**Consultation Response from KC,
Conservation & Design**

2025/91147 George Hotel, St George's Square, Huddersfield, HD1 1JA

Refurbishment and redevelopment of the George Hotel (including partial demolition, partial reconstruction and extension) to provide a 108-bedroom hotel with bar, restaurant, gym, conference facilities and ancillary facilities (Listed Building and within a Conservation Area)

Date Responded: 3/9/25

Drawing No : 8662-BOW-ZZ-ZZ-DR-A-P155

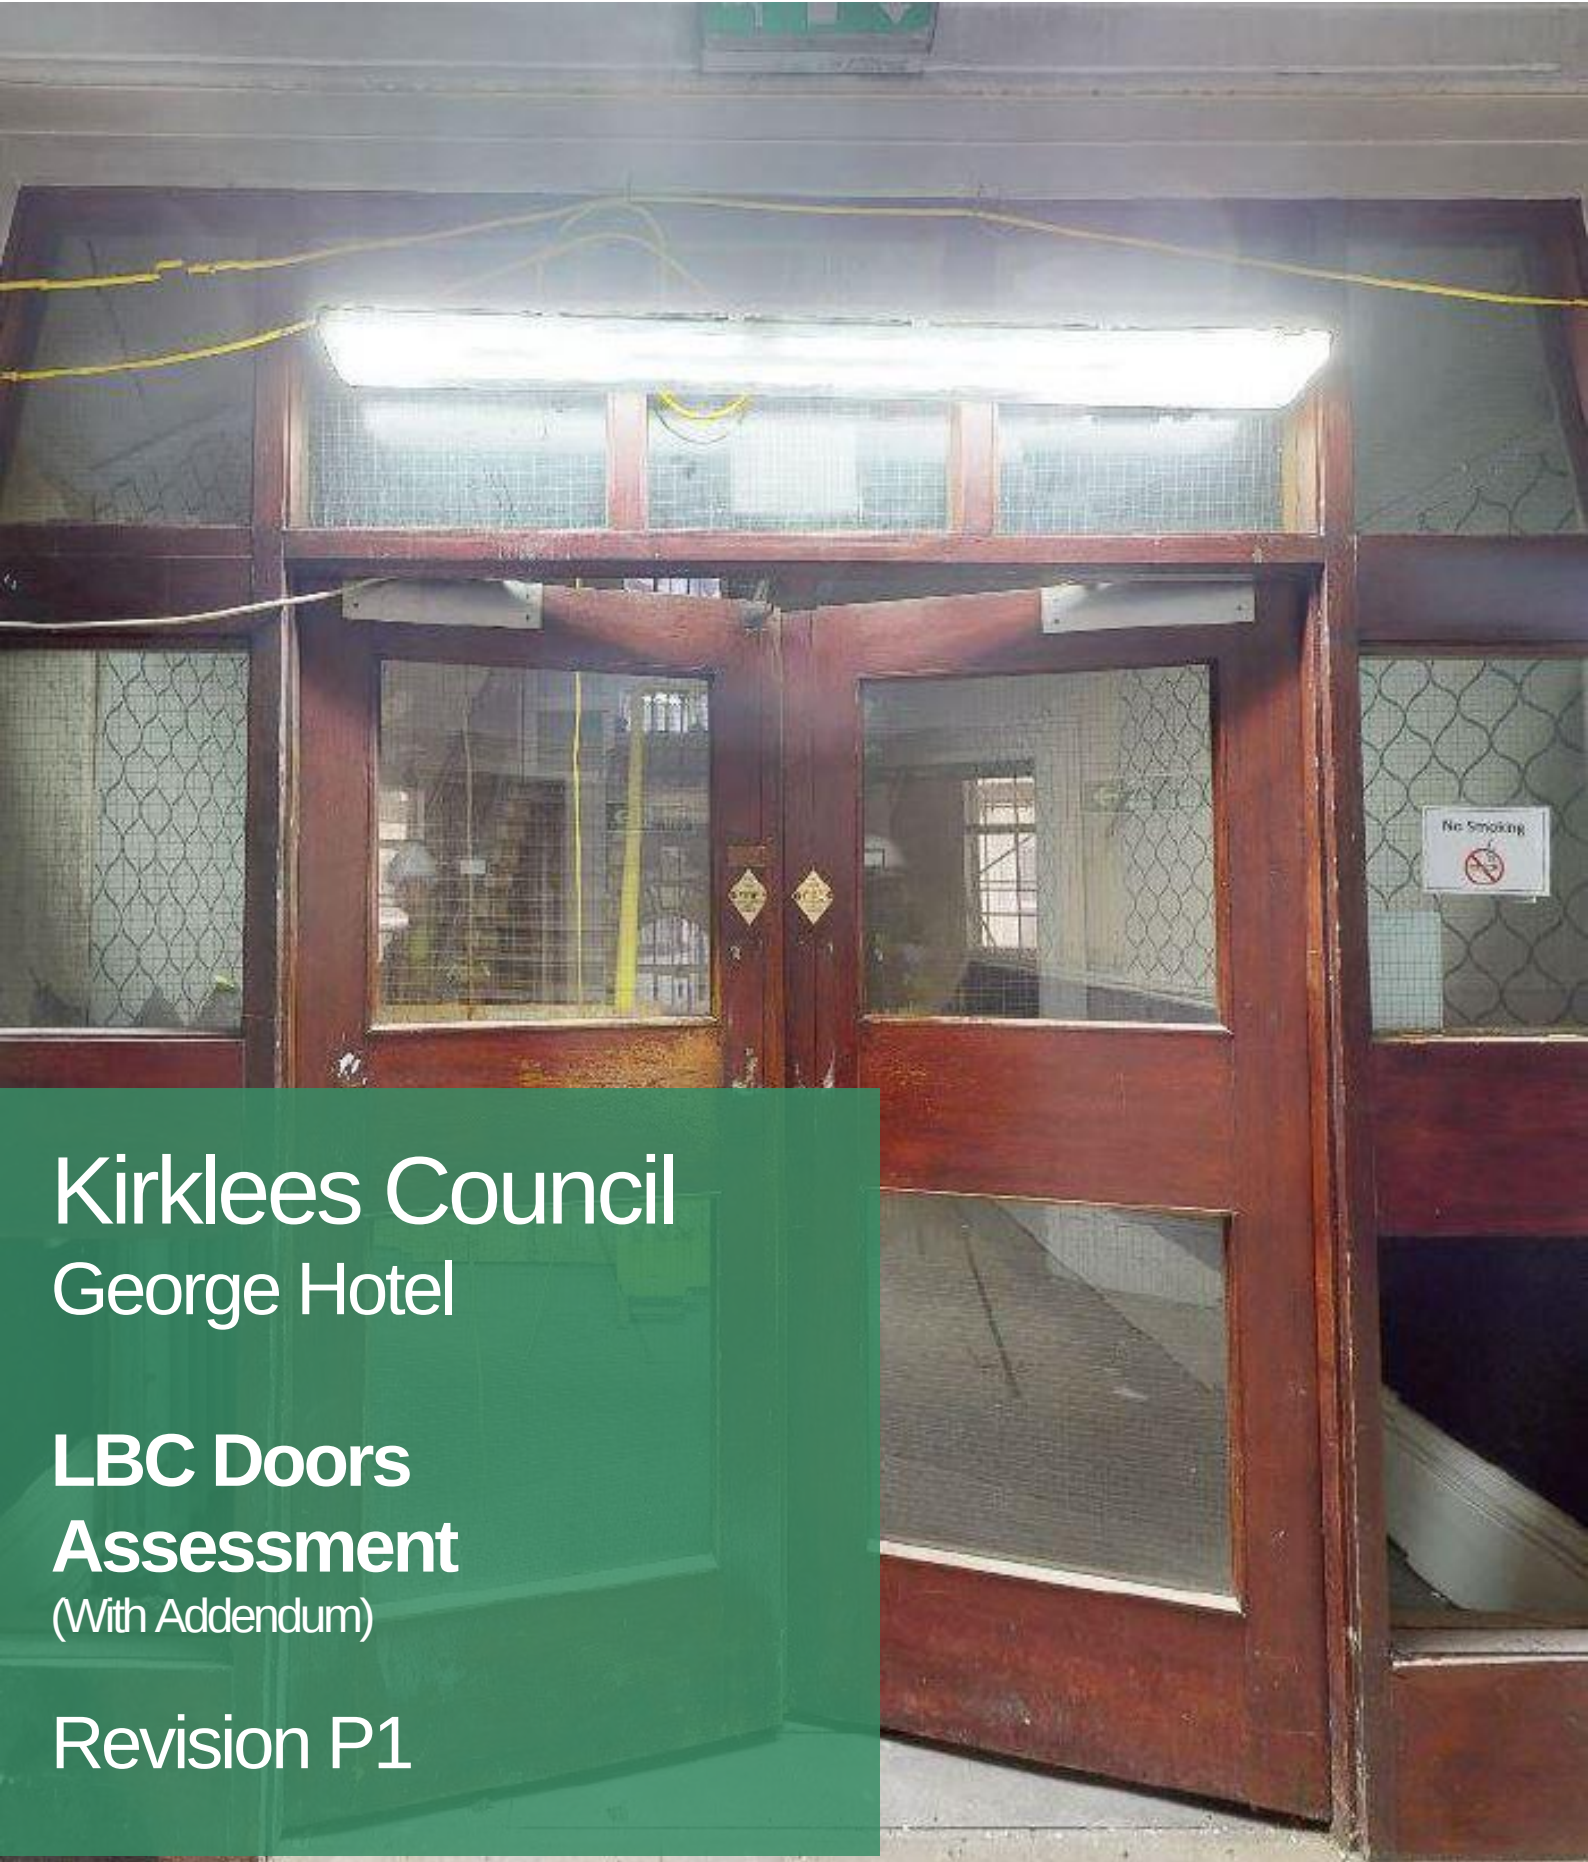
Door schedule – identifies a limited number (3) of historic panel doors to be retained (others are late

20th century fire doors).

E1 Reception - Elevation 1
1 : 50

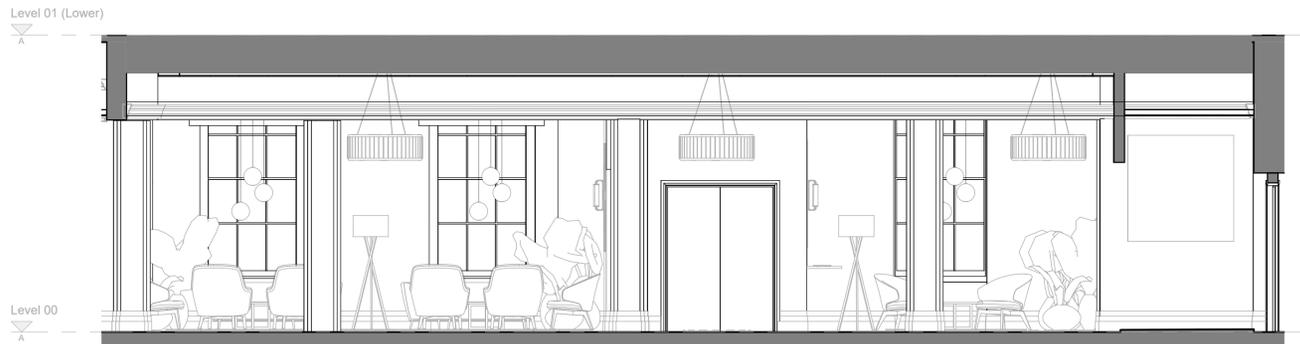
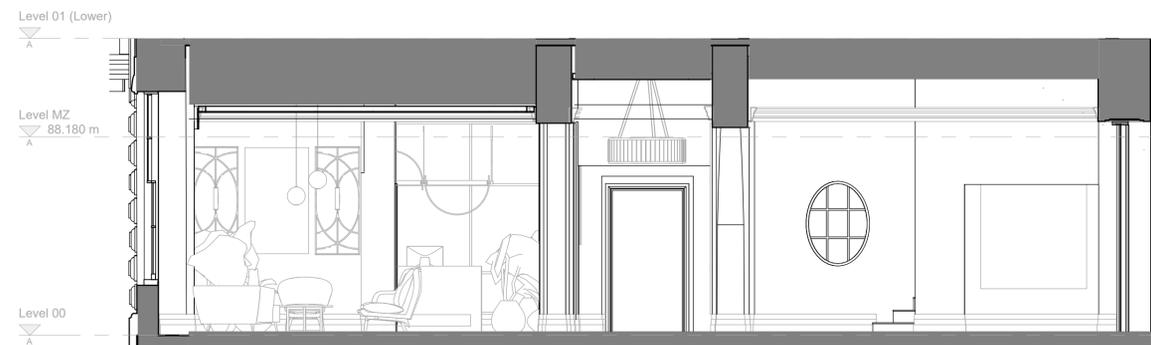
Reception – original fireplace, staircase and curved display cabinet retention is welcomed. Internal volumes and layout will reflect the 1851 planform with down stand beams to inform understanding. The 20th Century 1970's/1980's (low quality) alterations including coffered ceiling at the base of the stair will be removed to allow better understanding of the 1850's spaces. It is understood that there are 2 layers of decorative plasterwork existing; a higher level of circa 1930's plaster, with a lower level of 1970s/80s. Due to fire strategy compartmentation requirements, the plaster will need to be removed, but the intention is to reinstate the higher-level plasterwork to match the existing pattern.
